PLANNING AMENDMENT

Application No. H11/0996/02/A1 (DE)

PROMISED EXTENSION AND WORKS TO REAR OF HOUSE.

Amendment: Garage length increased

PLAN AS PROPOSED

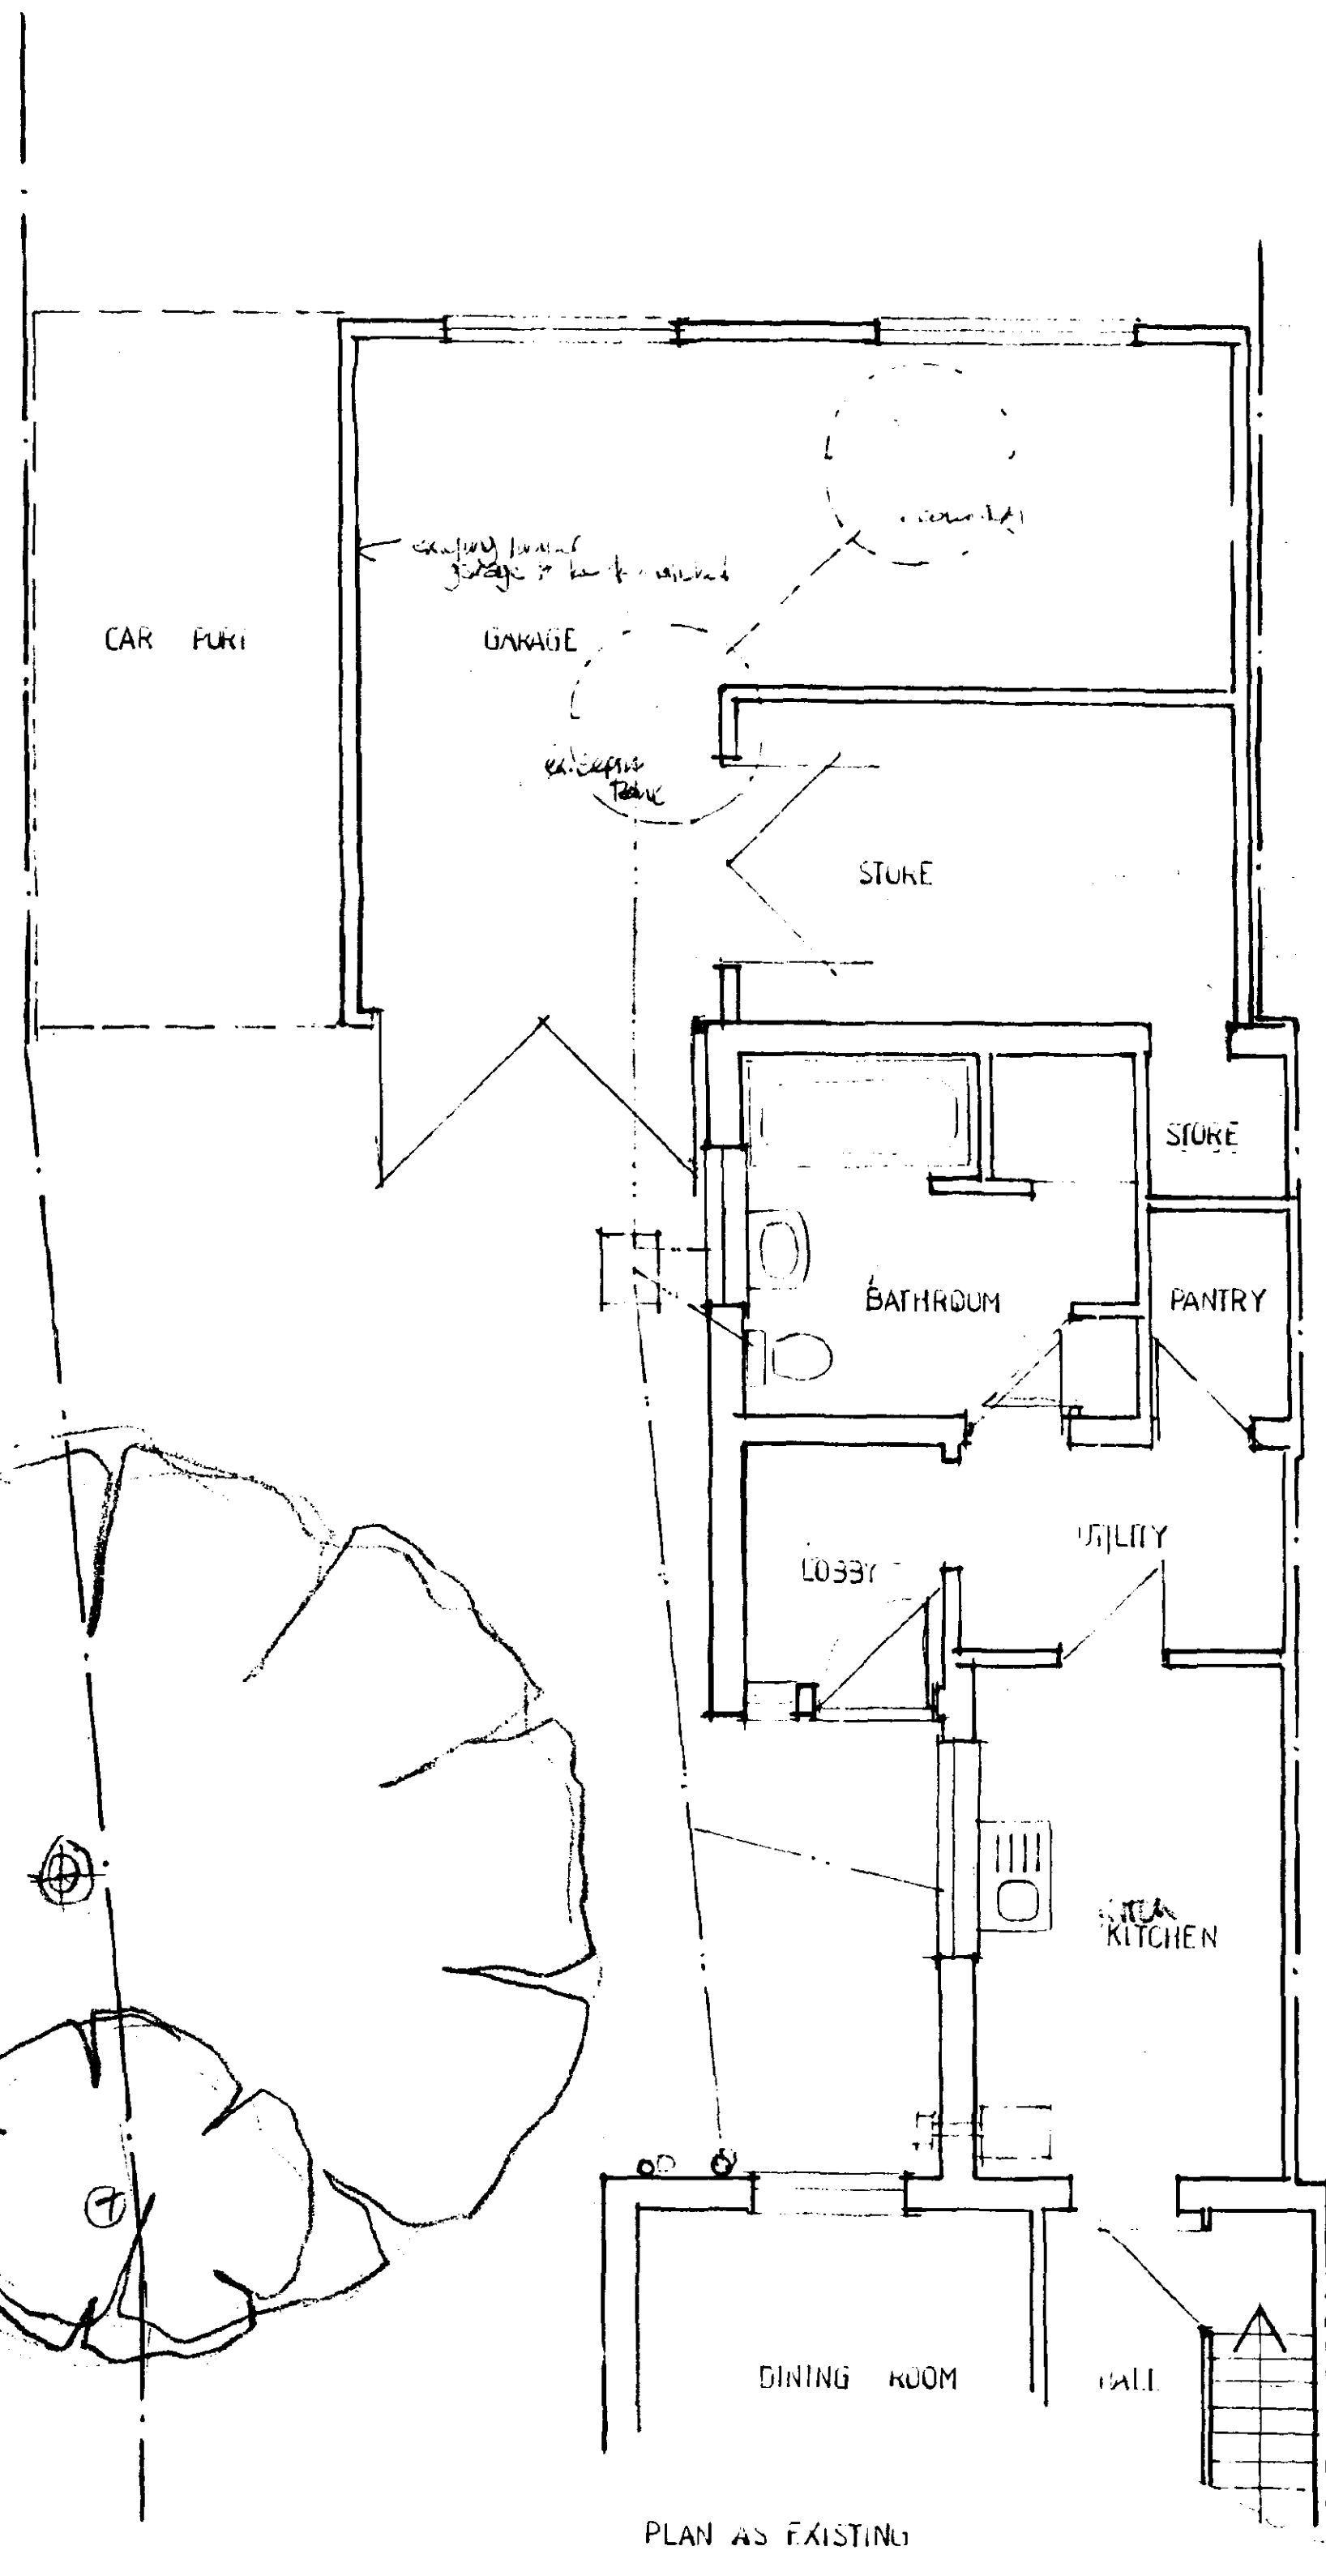
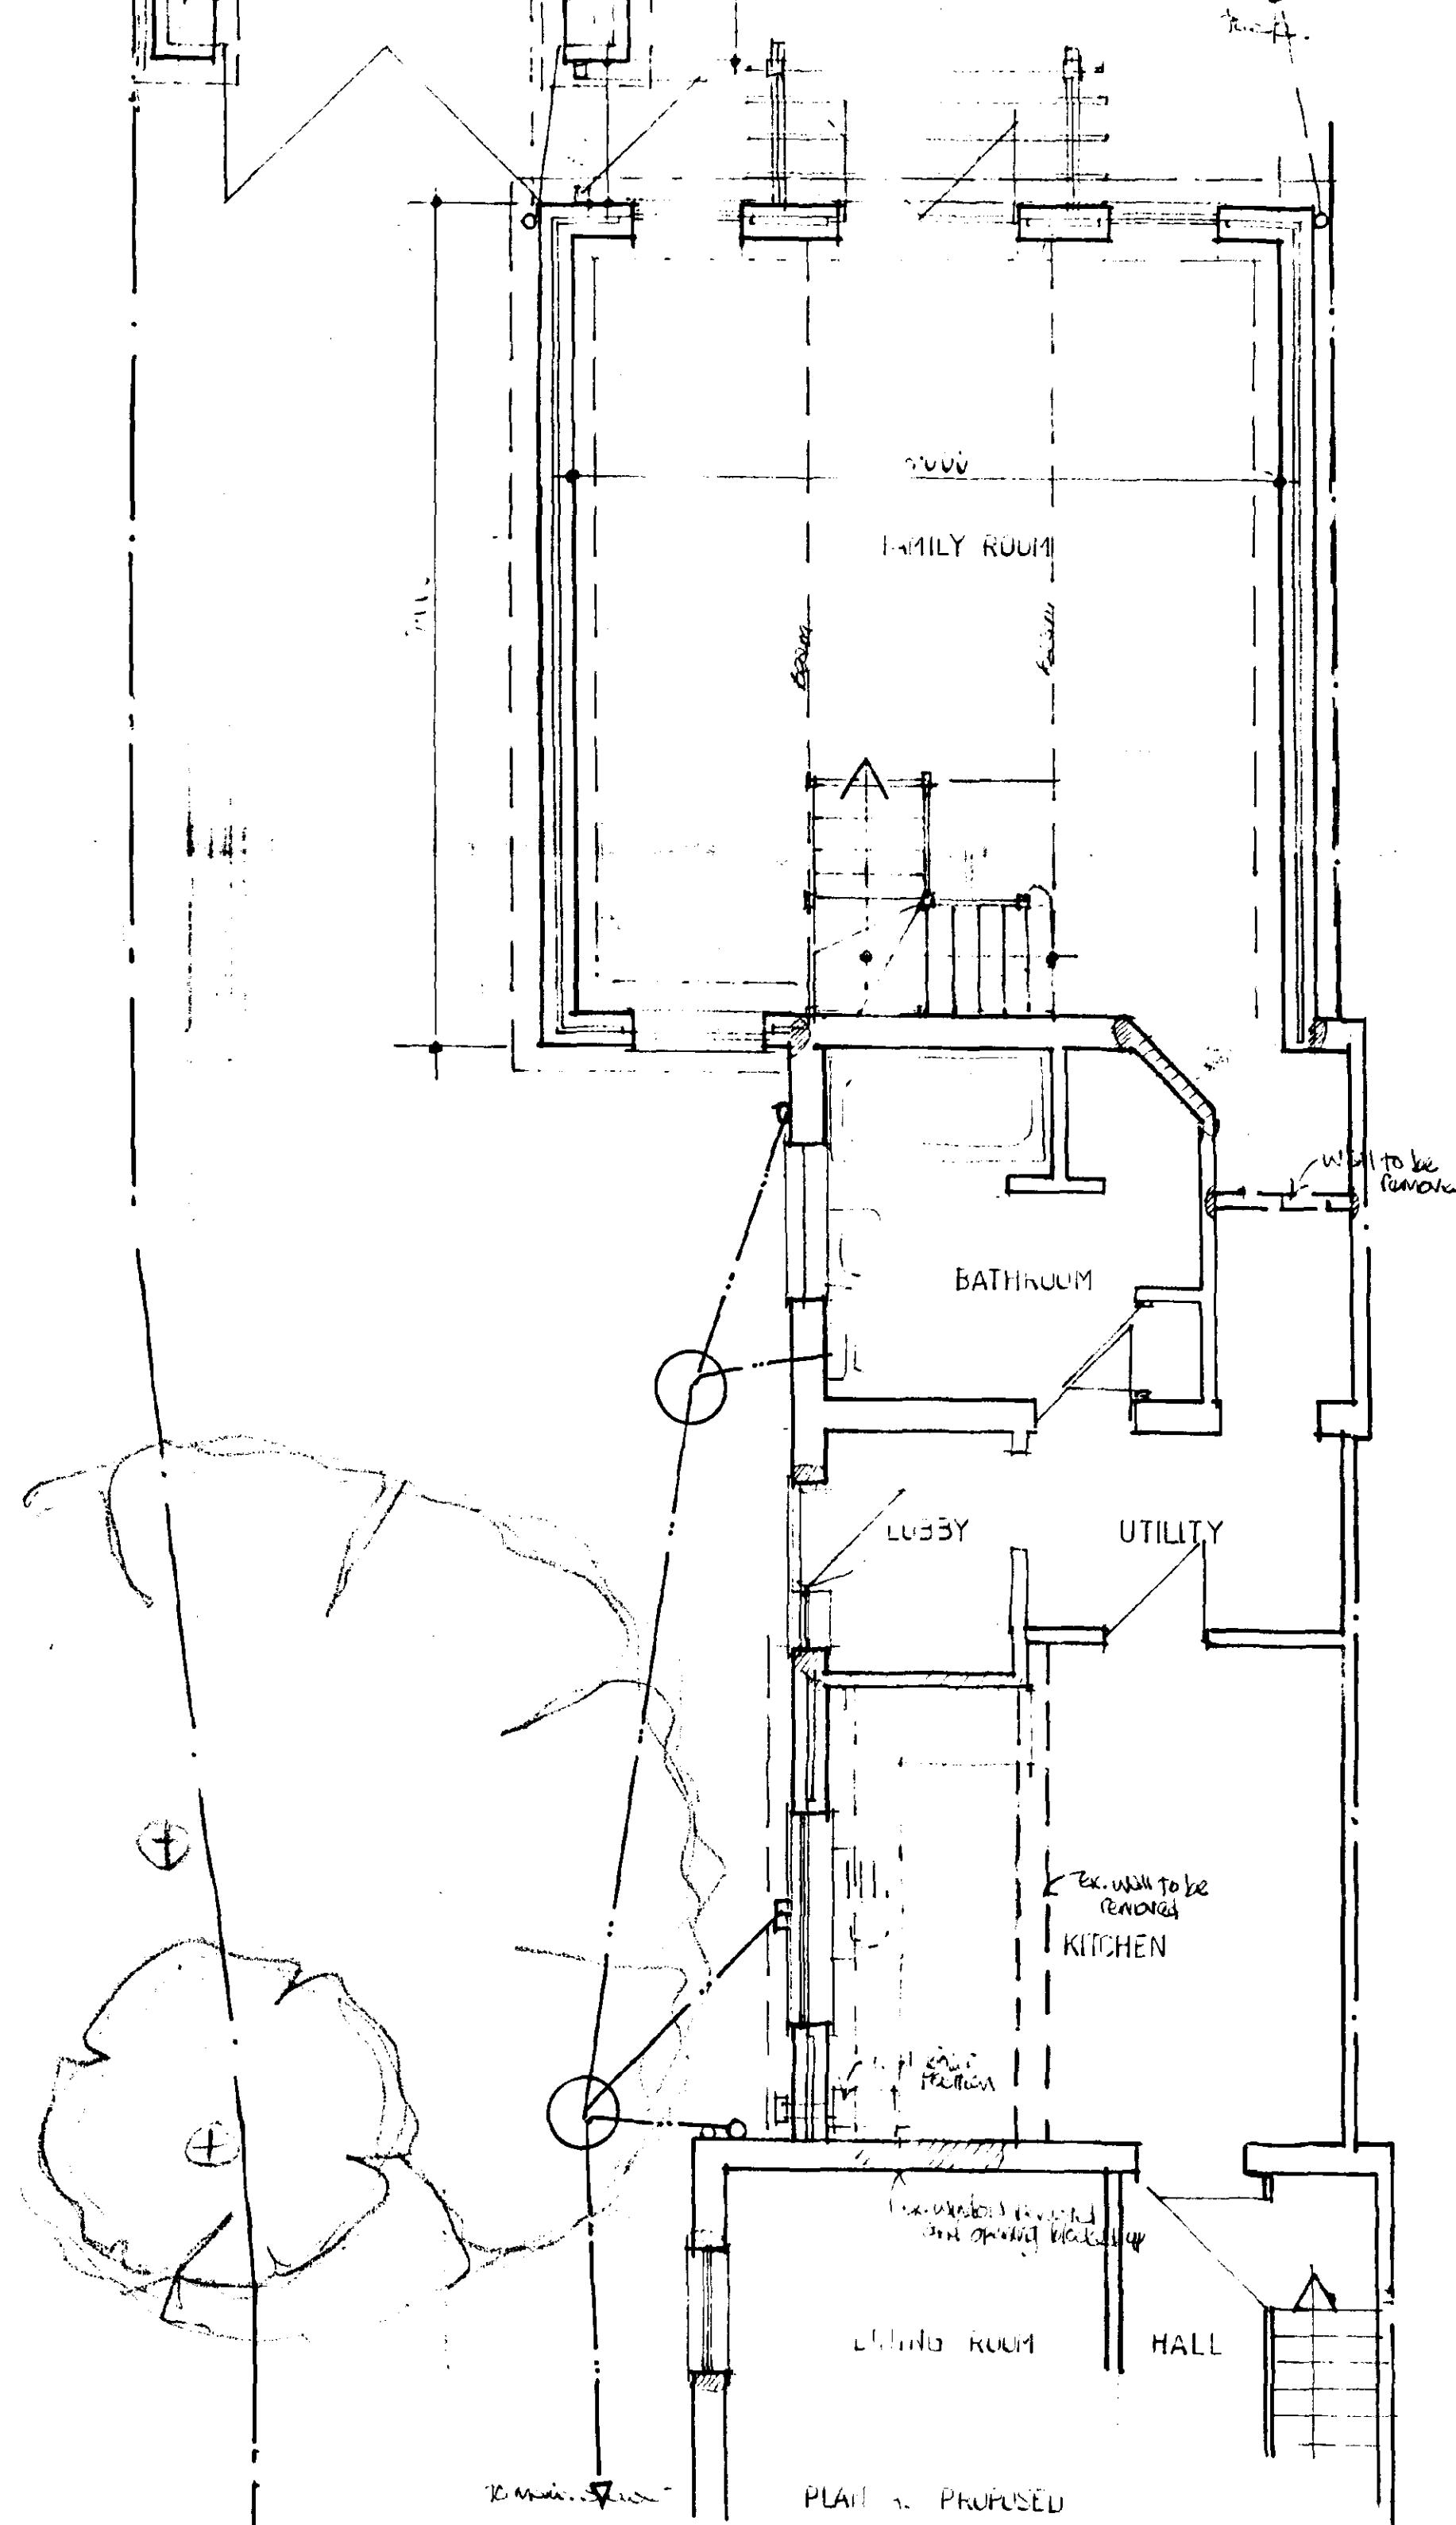
GARAGE LENGTH INCREASED AS DISCUSSED WITH MONICA
